CITY OF ALBUQUERQUE

September 26, 2018

RE: **ABC Building Expansion**
Grading and Drainage Plan
Engineer's Stamp Date: 9/20/18
Hydrology File: H14D001B

GRADING &  
DRAINAGE PLAN

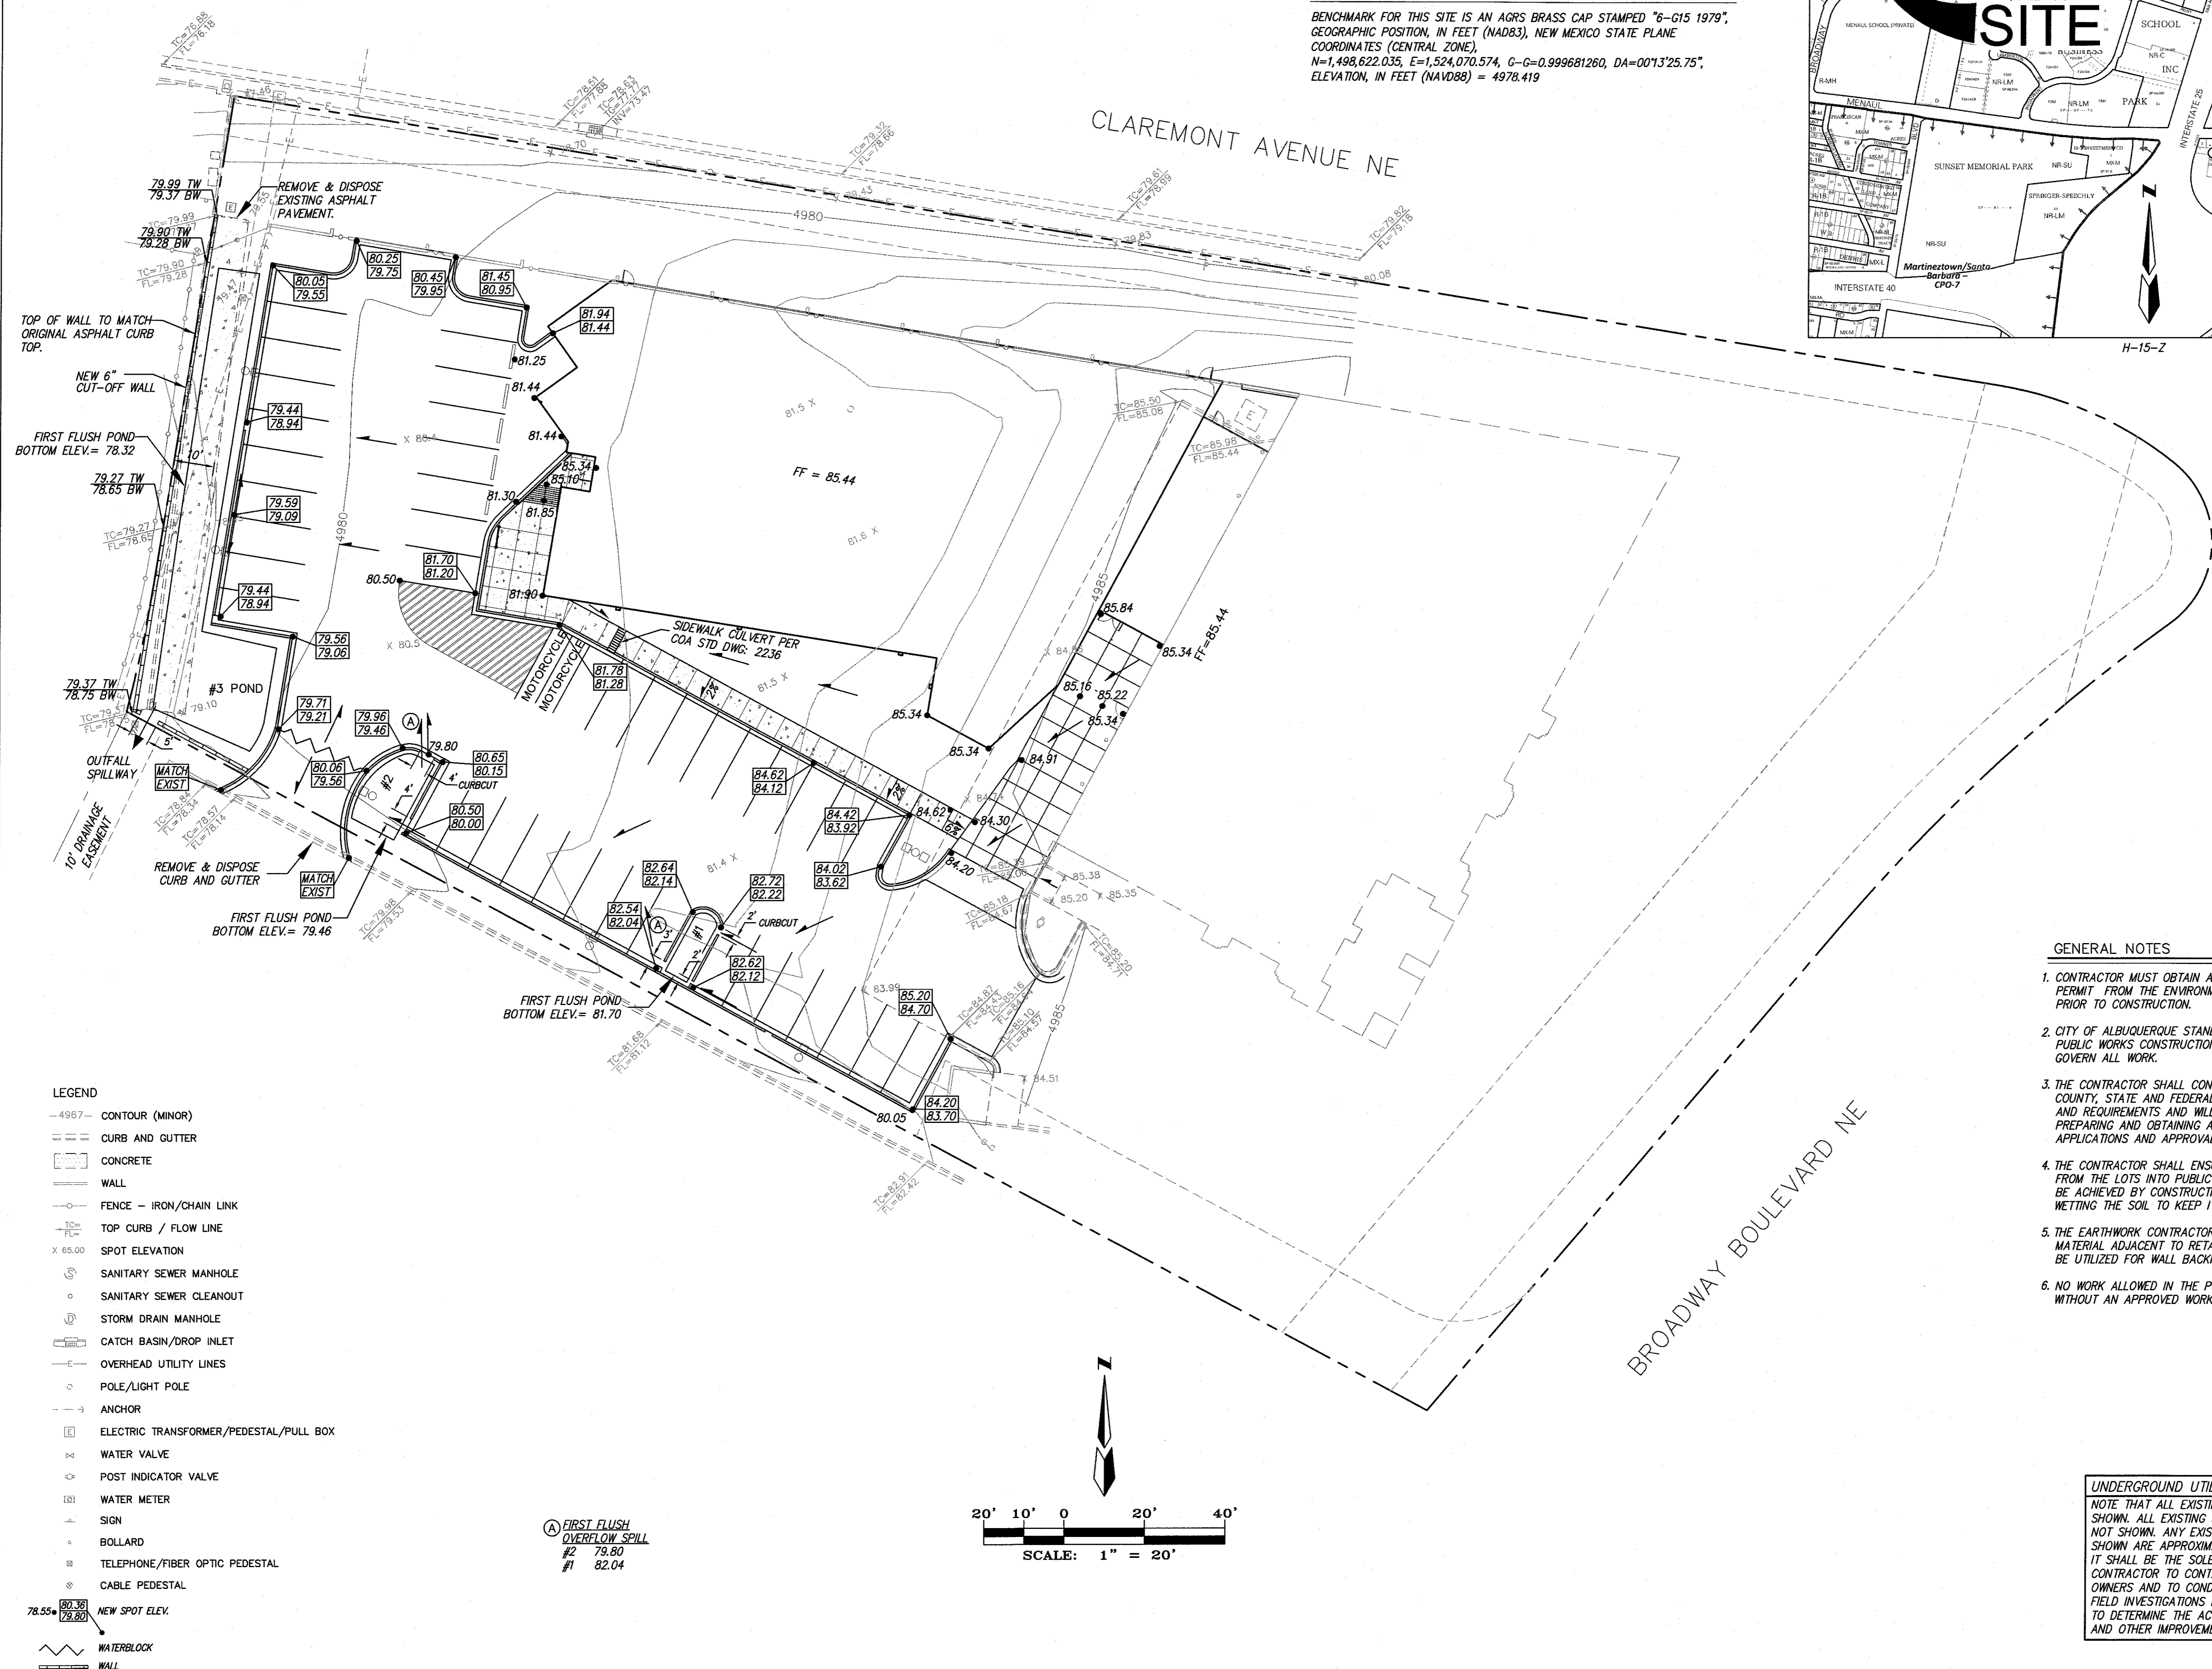
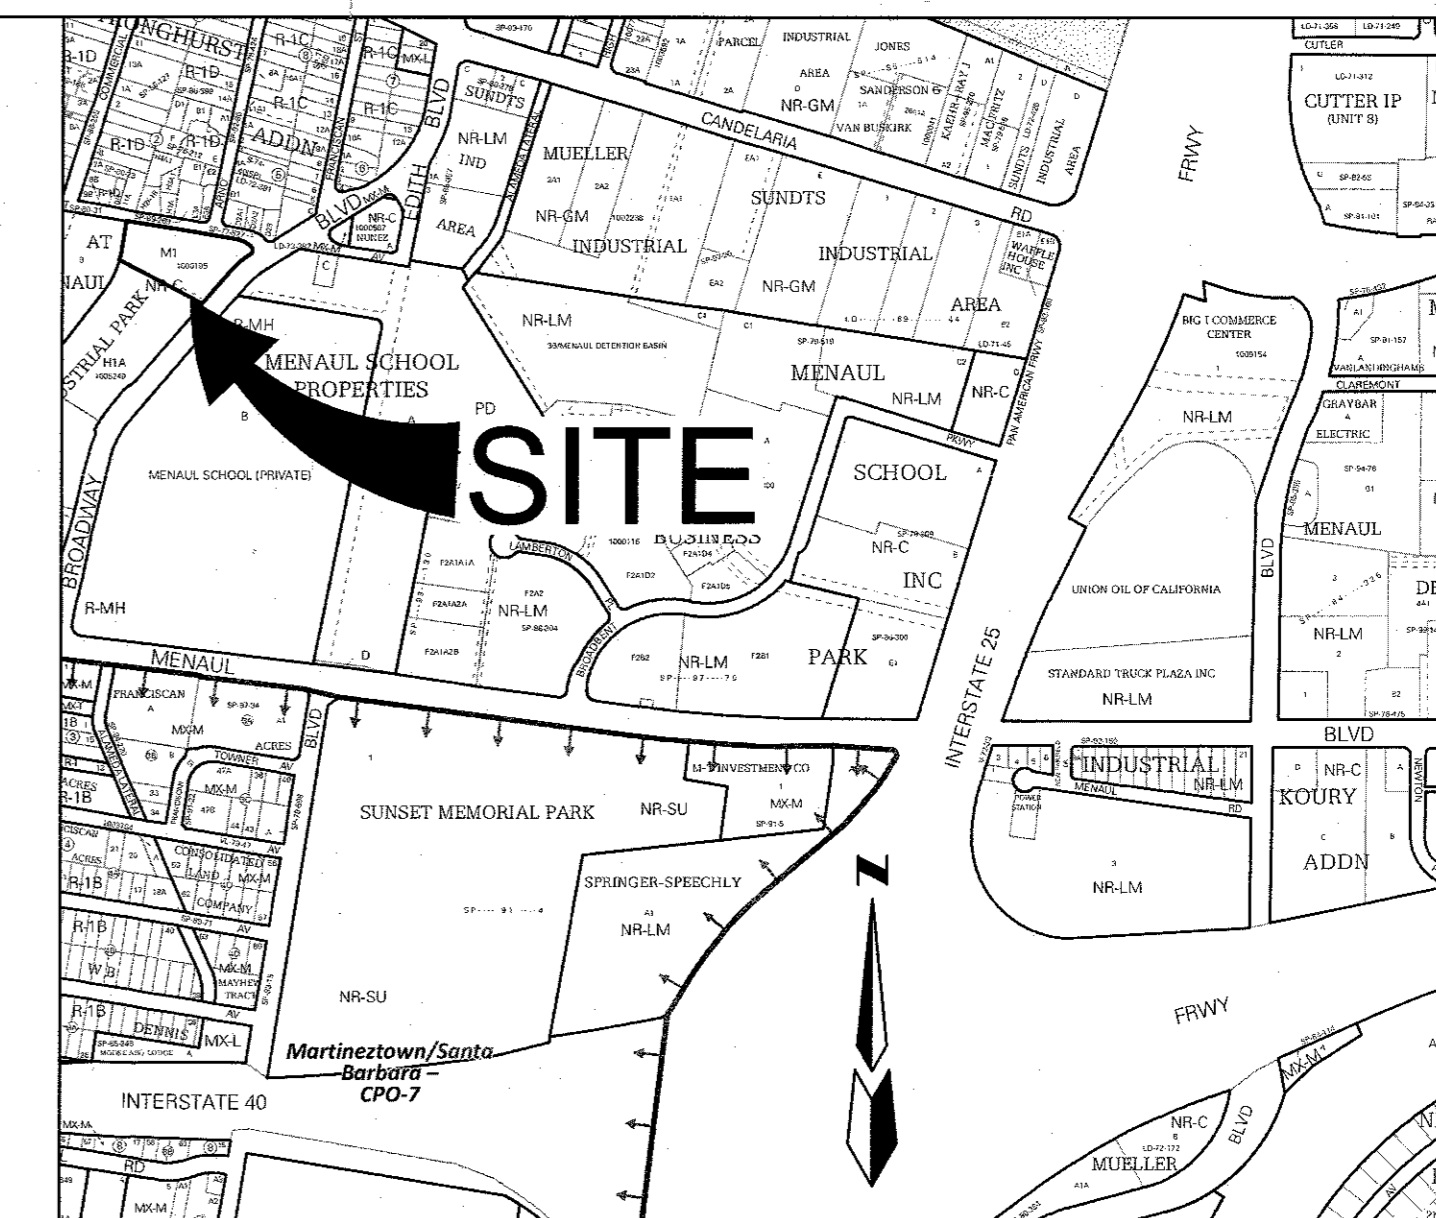
1. Provide written permission from the adjoining landowner (Tract H-1-A) for constructing the driveway access on their property (SW corner of this site).
